Submission No.			008	
Organisation Name or Name of Submitter			An Taisce	
Item No.	Section Ref.	Page No.	Observation Statement	TII Response
Letter Re: Railway Order Application- Metro North: Estuary through Swords, Dublin Airport, Ballymun, Glasnevin and City Centre to Charlemont, Co. Dublin				
1	1 Intro and Overarching Comments	1	We welcome the overall proposal as it is a long overdue strategic priority for the improvement and expansion of the public transport network in and around Dublin	TII welcome your support for the project.
2	1 Intro and Overarching Comments	1	The proposal needs to be integrated with a wider transportation initiative for the catchment area to reduce private car use and dependence, including the promotion of cycle-and-ride to use the Metrolink stations.	As detailed in Chapter 6 (MetroLink Operations and Maintenance), the proposed Project has been designed to ensure maximum interchange with other modes of transport, specifically other sustainable modes of transport such as walking, cycling and public transport. All operational stations will have pedestrian and cycle access, with bus stops located either adjacent to or within the site to facilitate integration

TARA STATION

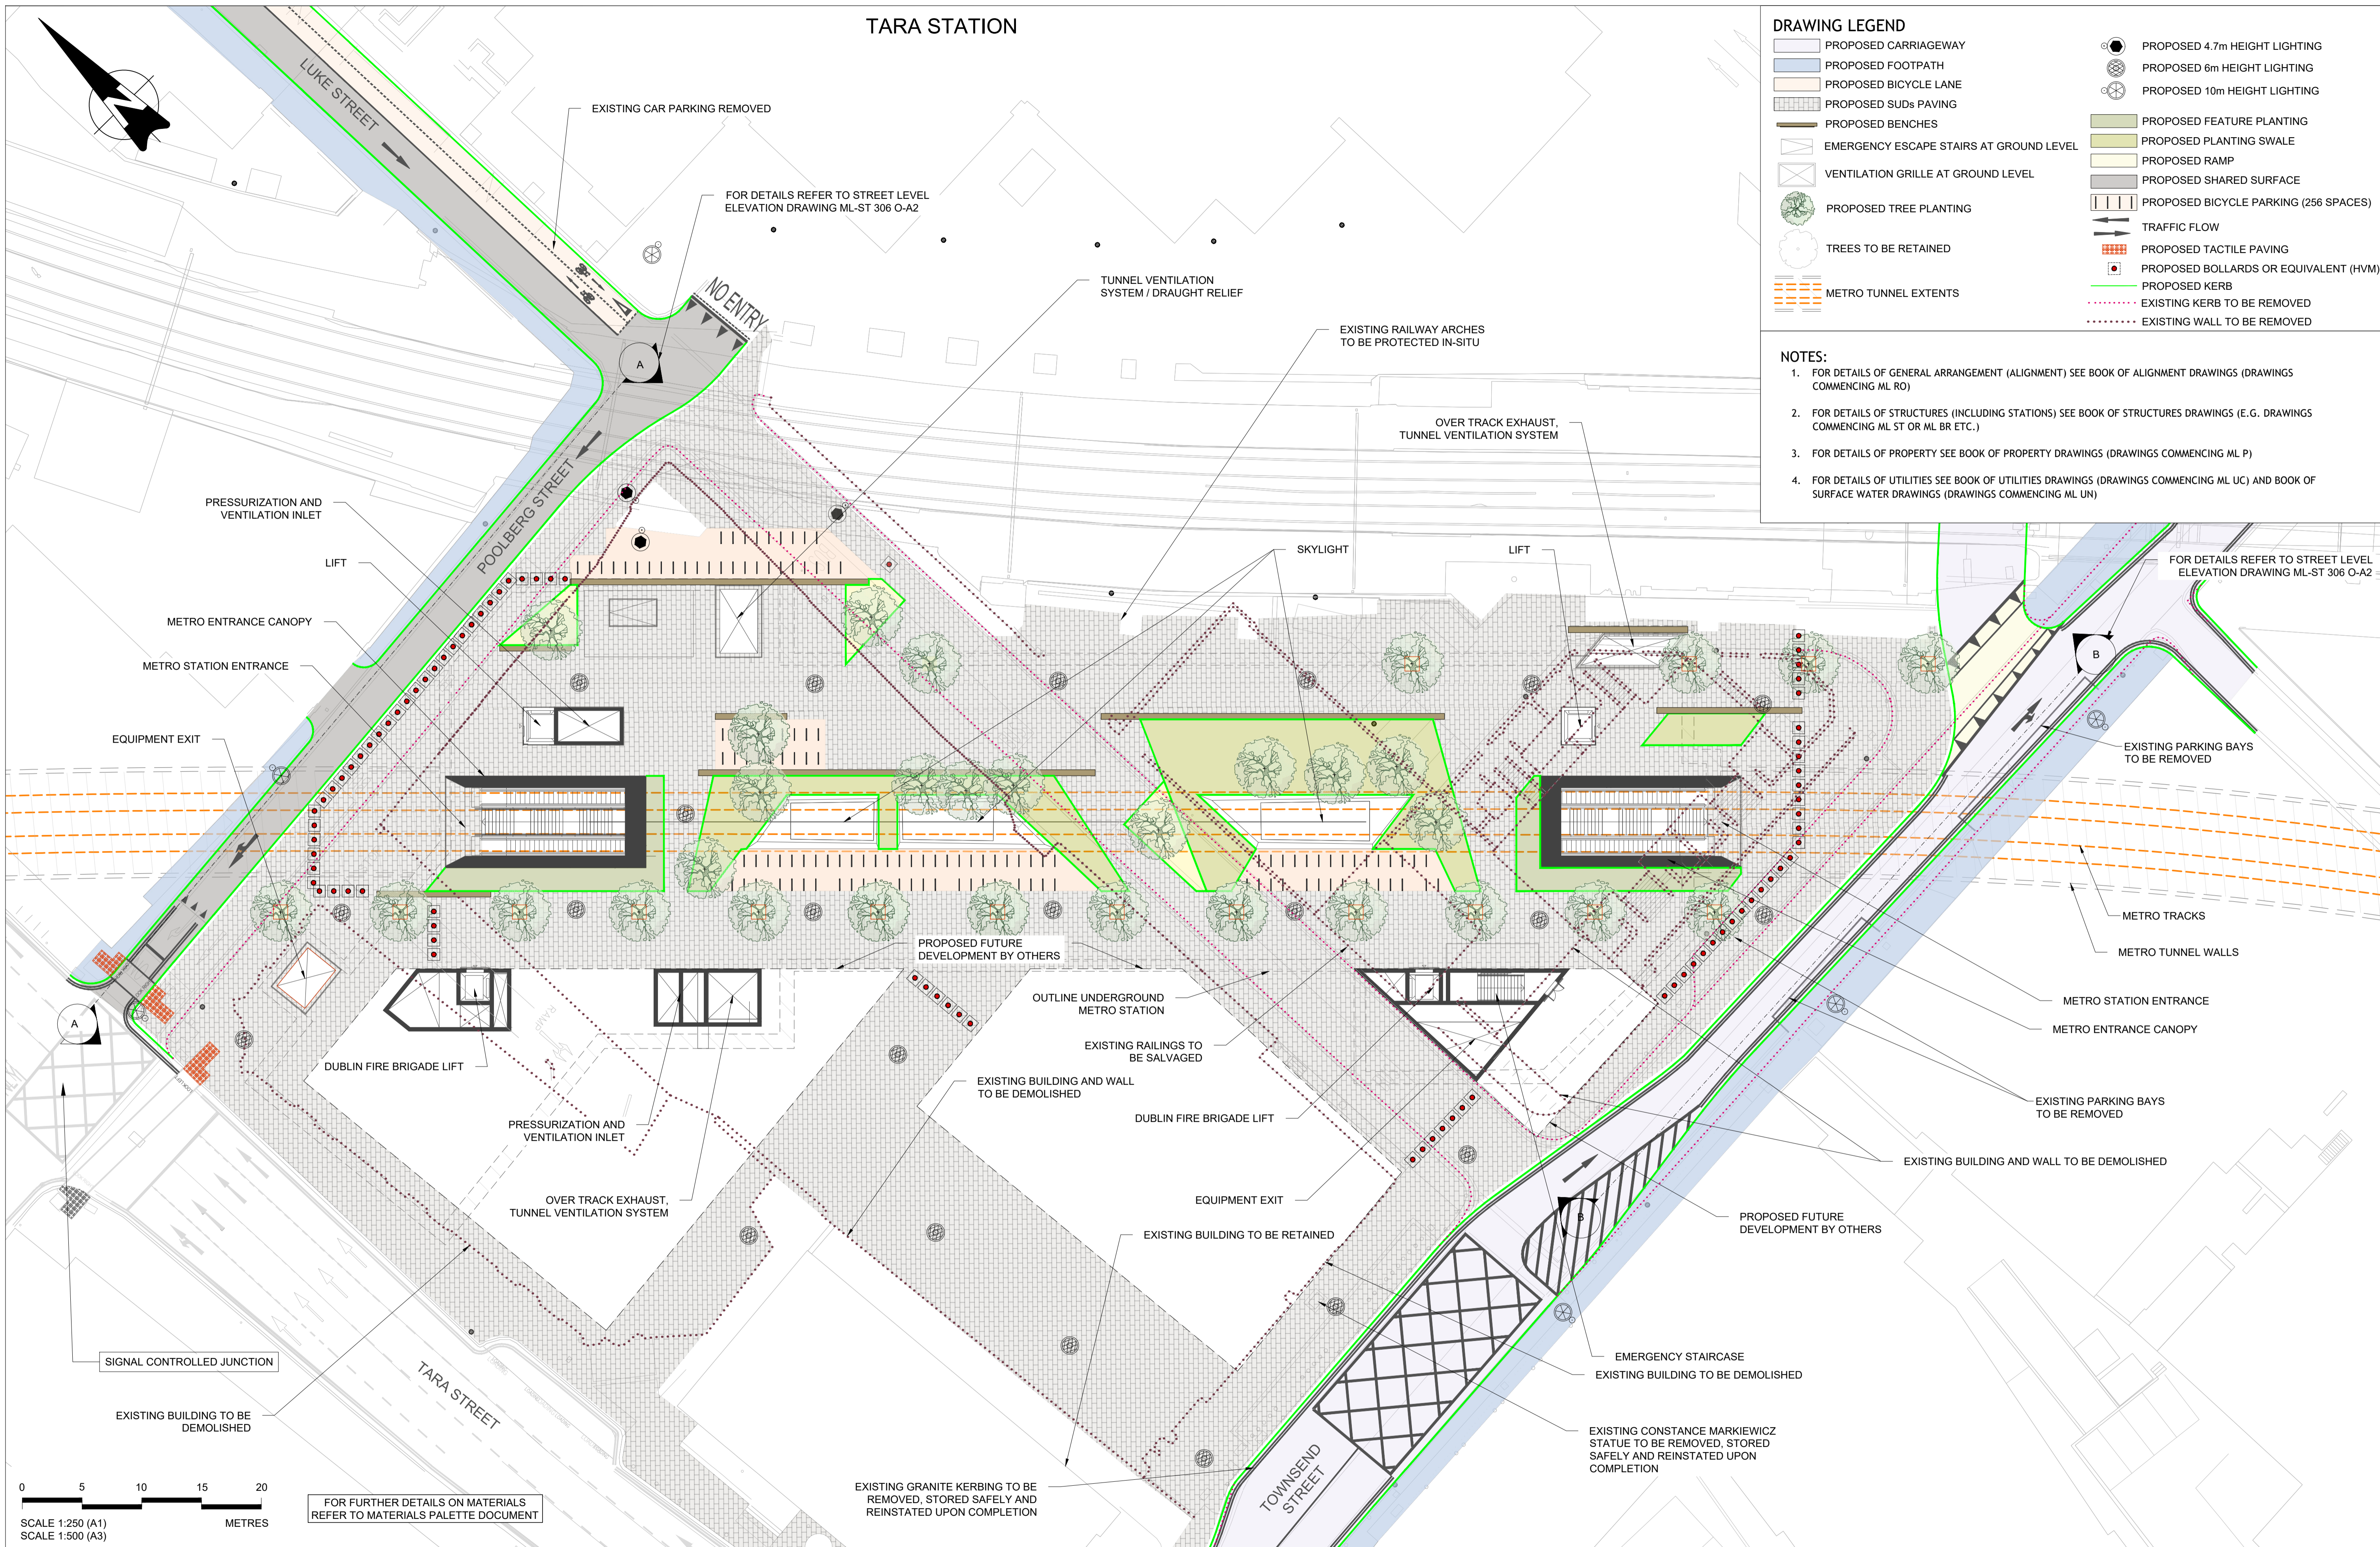
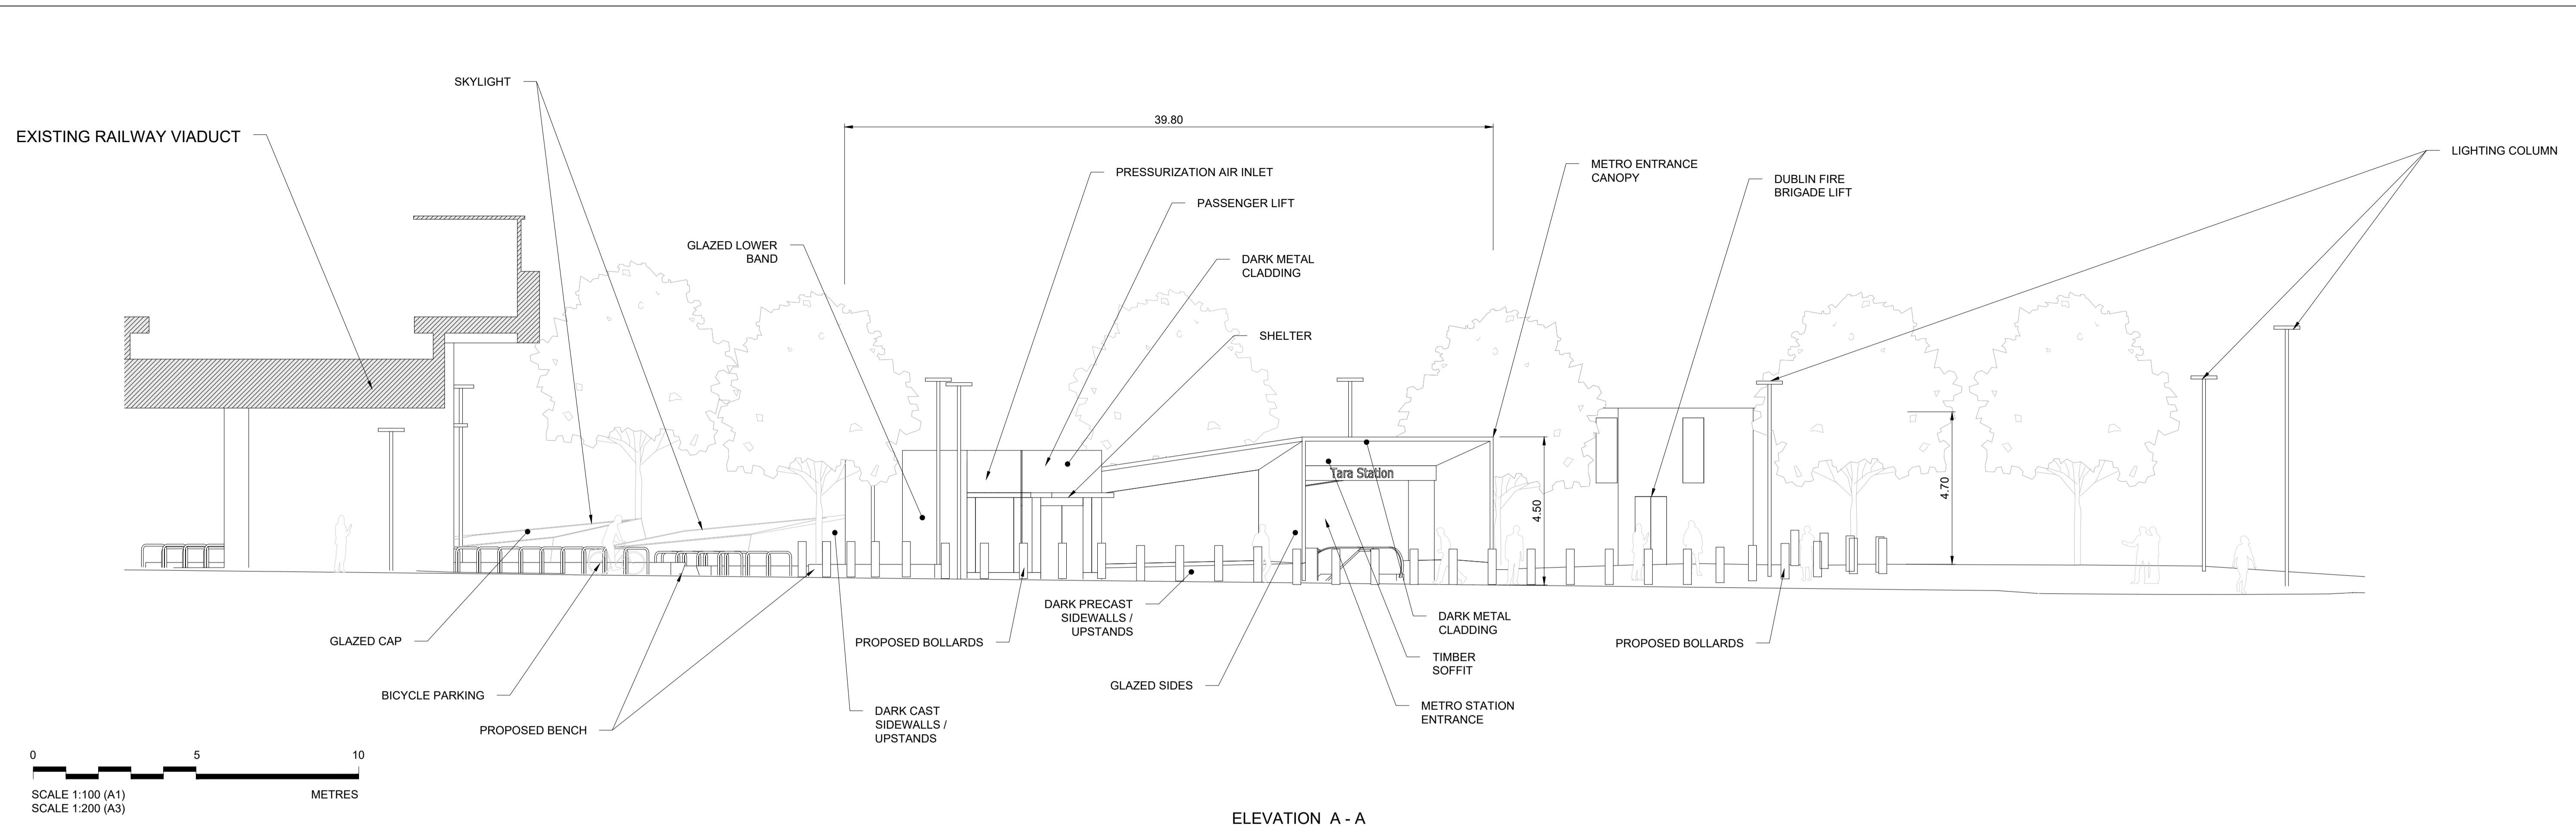
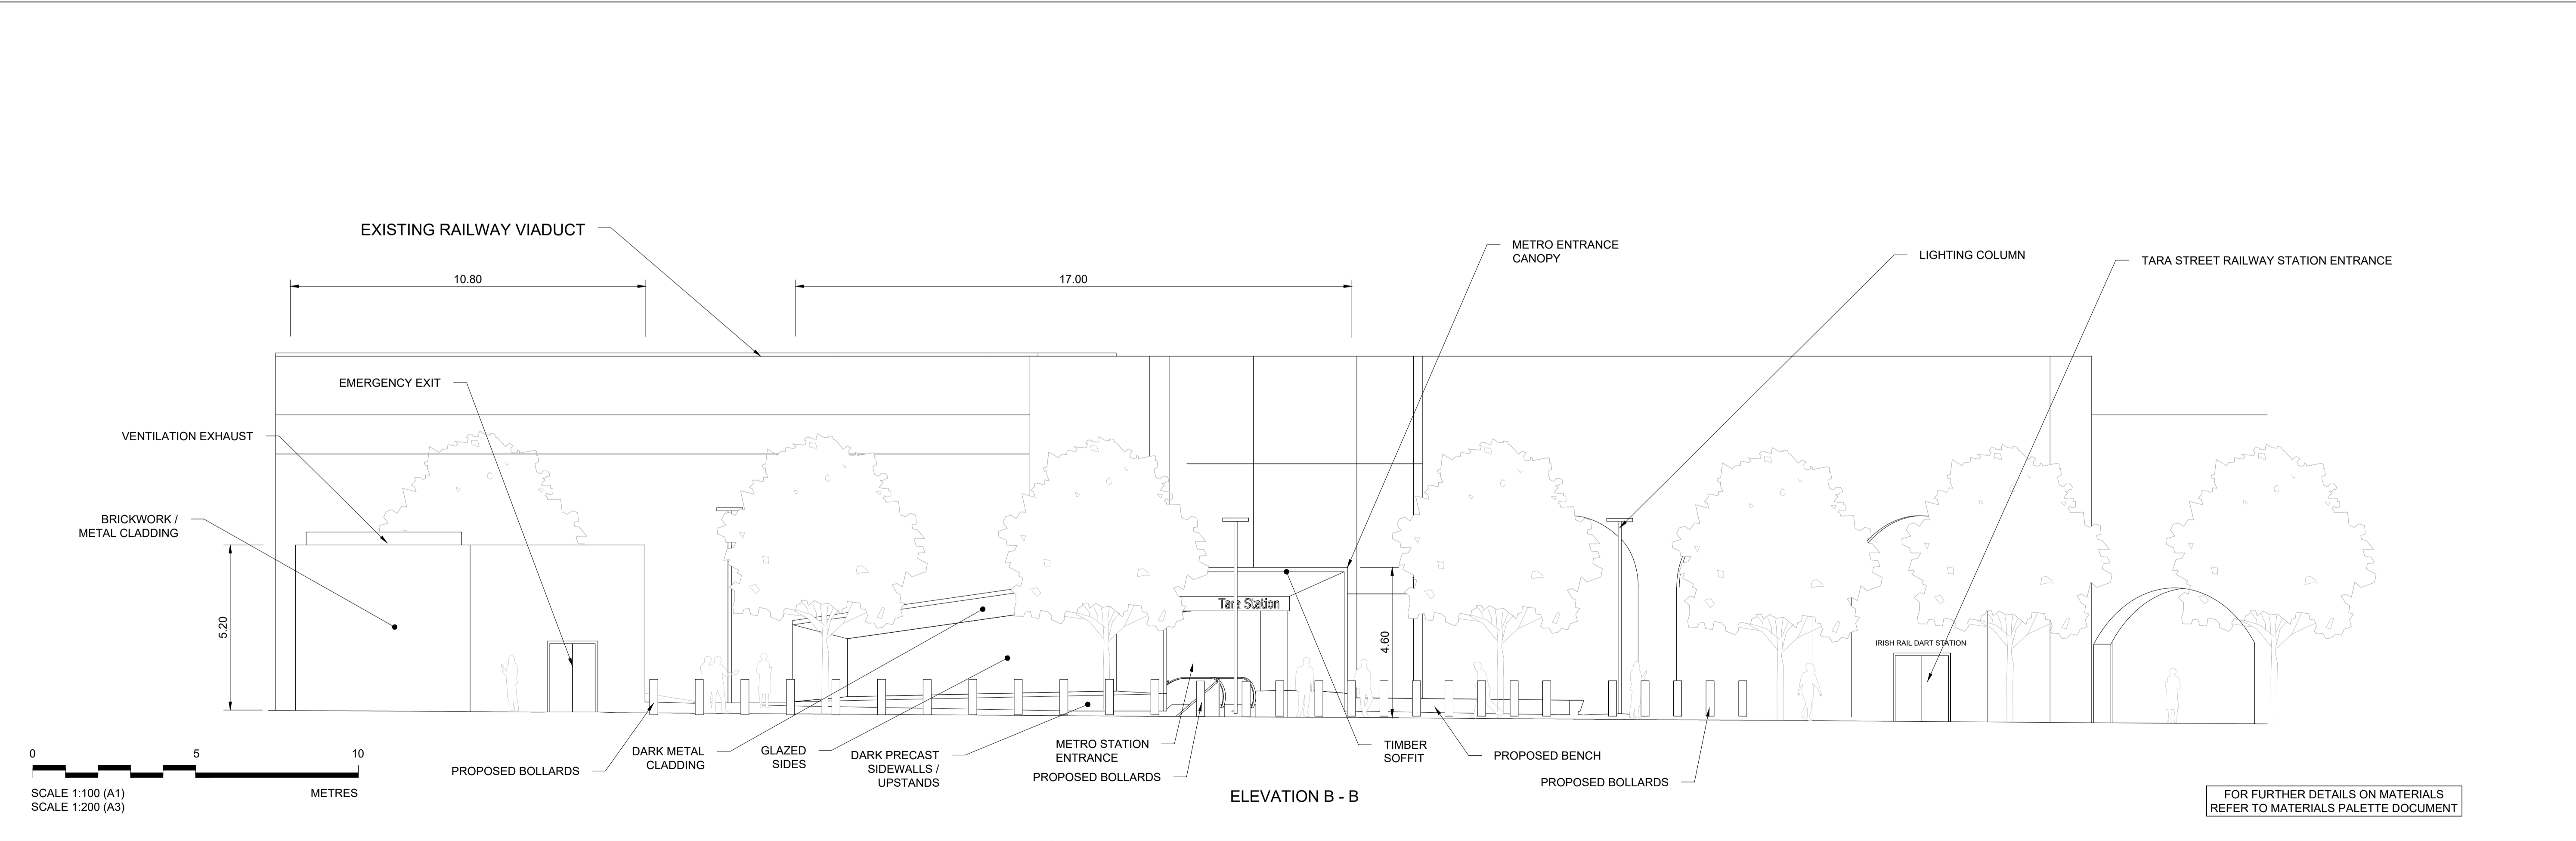
4	3 Alternatives to Demolition of the College Gate Building	3	We will now review the alternative designs for Tara Station, which were listed in the Preferred Route Design Development Report (PRDDR),but were not recommended for a variety of engineering based constraints mentioned above, which we recommend be reviewed by the Board. These are a modified version of Option3 Station moved southwards, which we suggest be considered if constructed as per option 4, to mitigate the major concerns outlined in the PRDDR.	Please note that the Option 3a as discussed in the EIAR is a modified version of Option 3 with mining as per Option 4 to eliminate the need to divert the Townsend sewer. The concept design for this option showed that there was insufficient clearance beneath the sewer to allow for the requisite station facilities and hence this option did not work. So, the suggested alternative has been assessed. This is clearly explained in Section 7.7.10.9.1 of EIAR Chapter 7. It is further noted that impacts on the Townsend sewer would remain. Please note the mining would be required to be undertaken 24/7 and hence result in similar impacts as Option 4 as discussed above in Item 5.

Submission No.			008		
Organisation Name or Name of Submitter			An Taisce		
Item No.	Section Ref.	Page No.	Observation Statement	TII Response	
Letter Re: Railway Order Application- Metro North: Estuary through Swords, Dublin Airport, Ballymun, Glasnevin and City Centre to Charlemont, Co. Dublin					
8	3.3 Option 3A. Suggested alternative to Option 3 (using impacts to the construction techniques of option 4)	6	By adopted same construction methodology of option 4 construction and the major disruption with the diverting of mains sewers, the closing of Townsend Street to traffic during construction and the building on Spring Garden Lane needing to be demolished could be mitigated. Also, as per options 0 and 4, Tara Station will act as a multi-modal interchange station between Metrolink and DART railway line. The main point of interchange between the two stations will be via the southern entrance to Tara Station, with MetroLink access remaining as per option 3. Although the same construction methodology of option 4 would involve mitigating similar engineering related constraints and risks as per this option, but as per our comments on option 4, these Project Risks and Constraints have been successfully mitigated on other underground metro stations, elsewhere, and we would therefore recommend that Option 3A be considered, as an alternative to Option 4, if An Bord Pleanála deem that the College Gate building should be retained.	Refer to Item 4.
